Response to Issues – City of Sydney

80-88 Regent Street, Redfern – SSD 7080

Initial submission

Job No.	Drawing No.	Revision
5359	DA-0501	/ 8

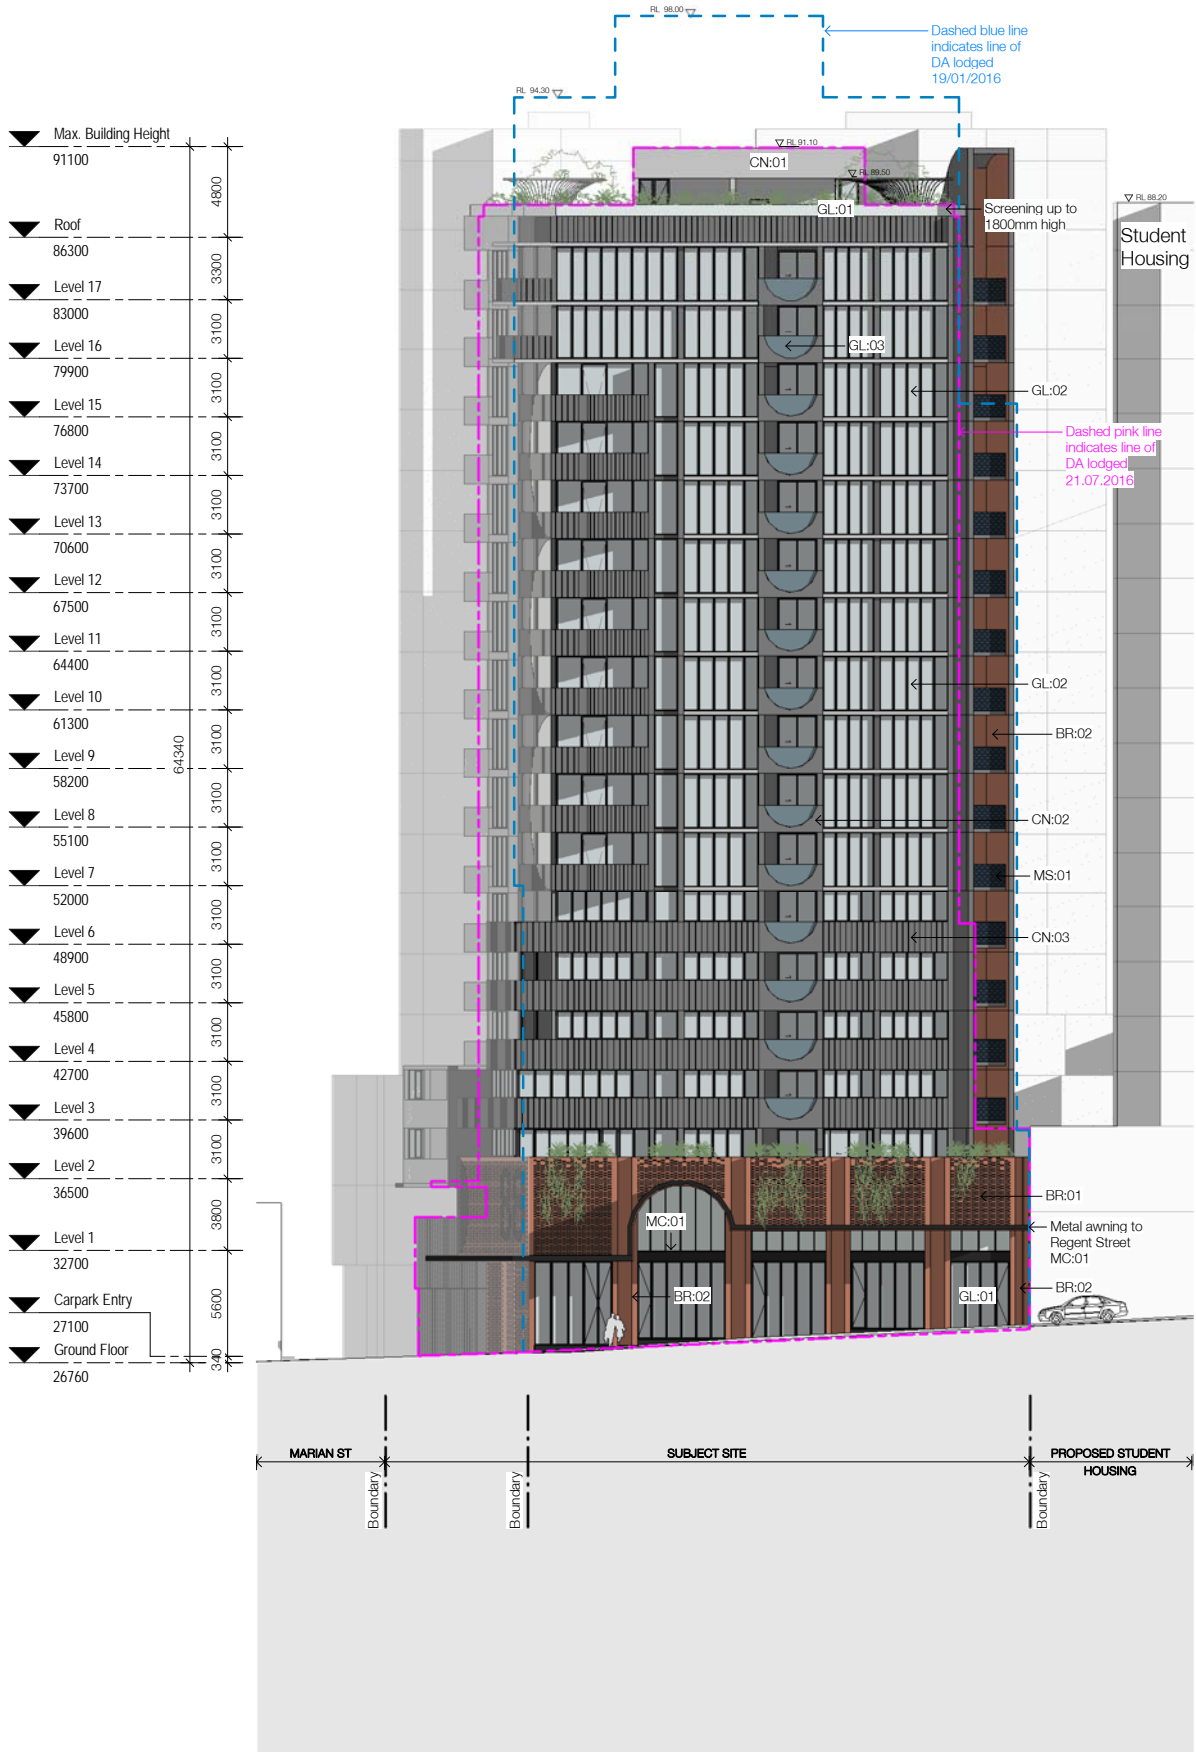
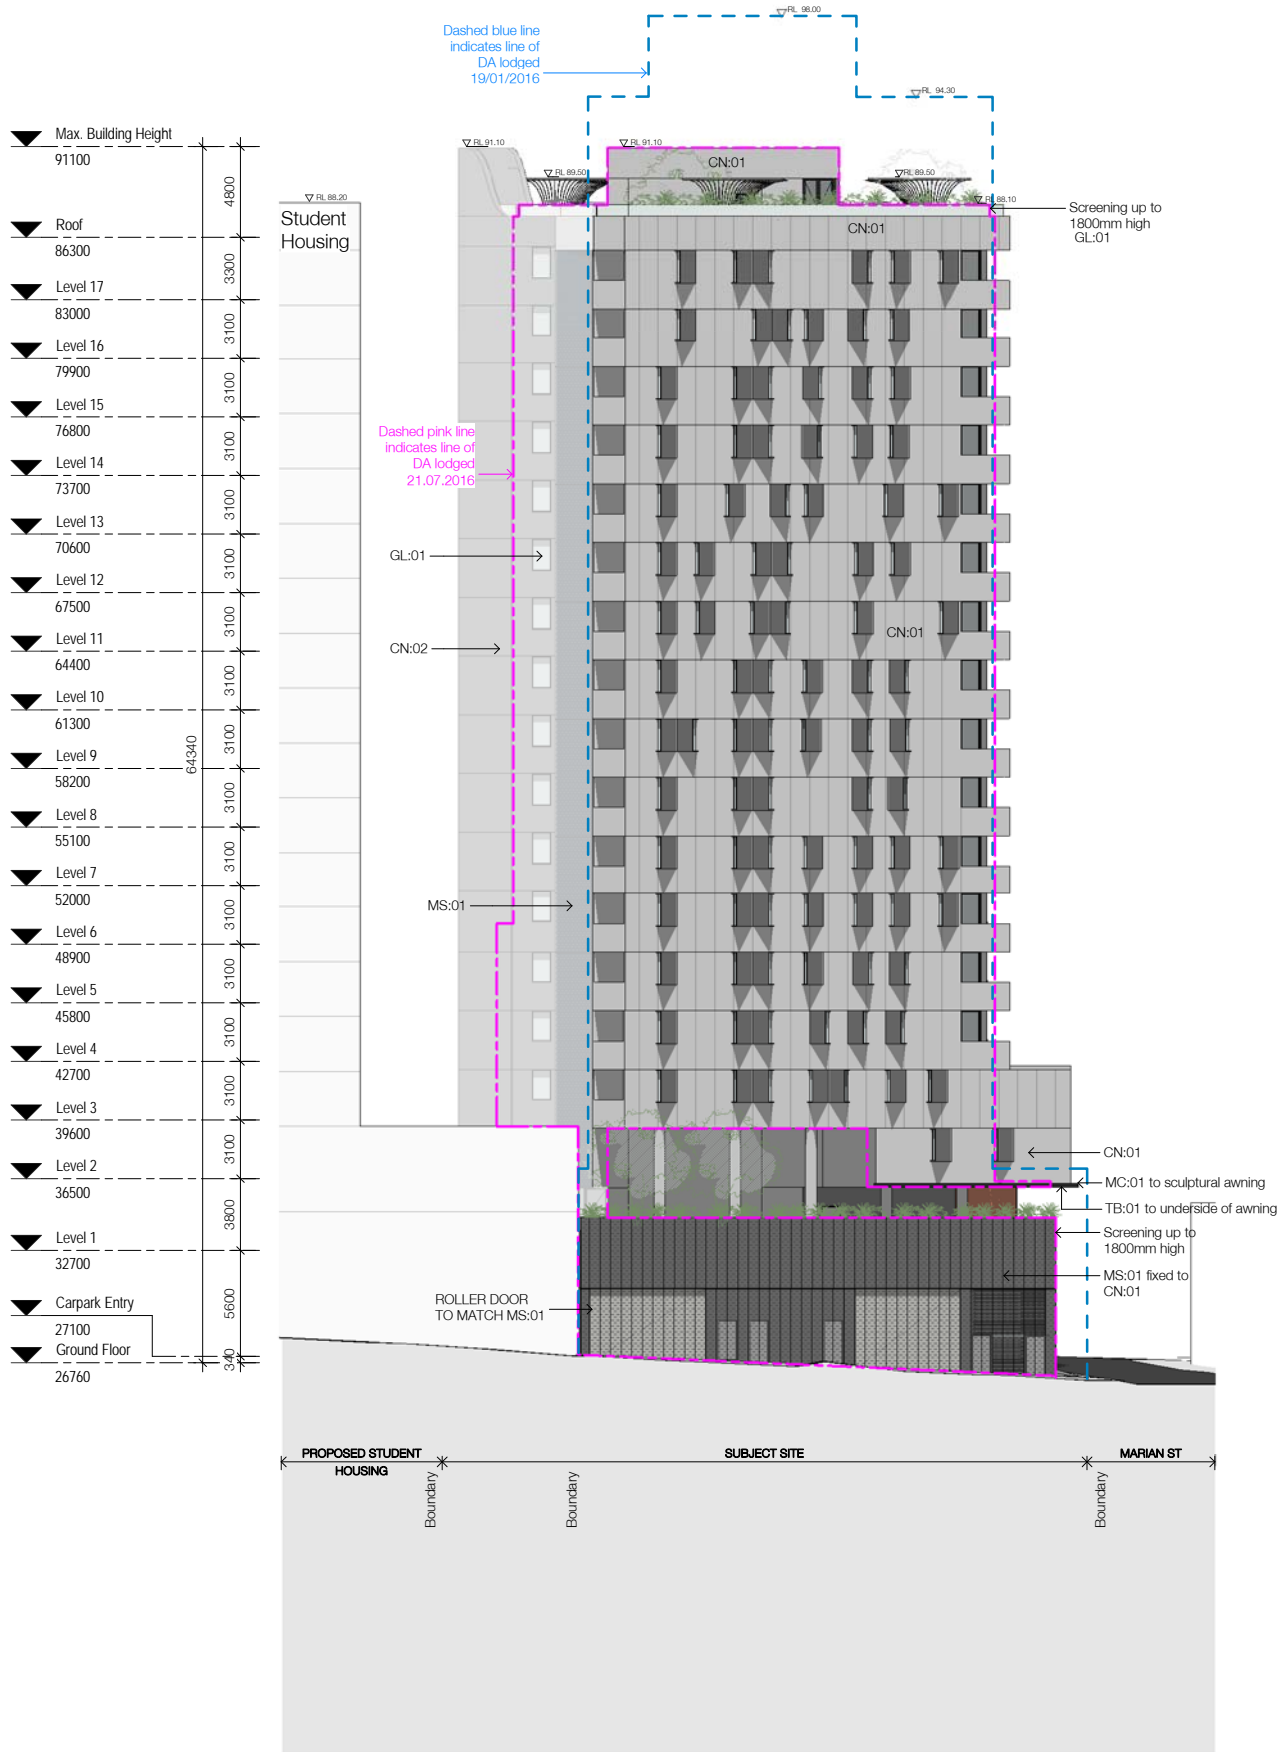
<i>6. As outlined above, the building has the height, bulk and mass of a 20 storey building and by definition is a 20 storey building. As such, the proposal does not comply with the 20 storey height control.</i>	Building height has been reduced.	
	<u>Recommendations</u> <ul style="list-style-type: none"> The height in storeys non-compliance should be addressed. A number of strategies are recommended: <ul style="list-style-type: none"> provide genuine mezzanines, intermediate floors that are part of the room below; create a genuine floor above Ground Level where the extra ceiling height is not required and remove the 'mezzanine' above Level 17. This would reduce the overall height by 2 storeys, reducing the overshadowing impacts of the proposal and complying with the MP SEPP control; 	Building height has been reduced through the removal of the mezzanines.

<ul style="list-style-type: none"> – reduce the bulk of the floor above Level 17 by shaping the top of the building and locate the mezzanine levels in a contiguous floor plate around the core to provide an area of consolidated open space on the roof. The shaping of the top of the building may reduce the extent of overshadowing, however a redesign of the common open space may be required. 		
	<ul style="list-style-type: none"> • A review of the functionality of the child care centre is required, particularly with regard to: <ul style="list-style-type: none"> – the centre being split over two levels, with a large void in between. While the arrangement may work from a development perspective, it may not be suitable for the child care workers and their clients as there is only one lift servicing the connection between ground and Level 1 or a vertical height of 9.04m of stairs to climb; – the residential lifts are shown opening to the Level 1 of the centre, creating potential safety and security concerns. 	The layout of the child care centre has been revised so that it is located over a single level;	Refer to Section 4.8, and amended architectural drawings Attachment 1.
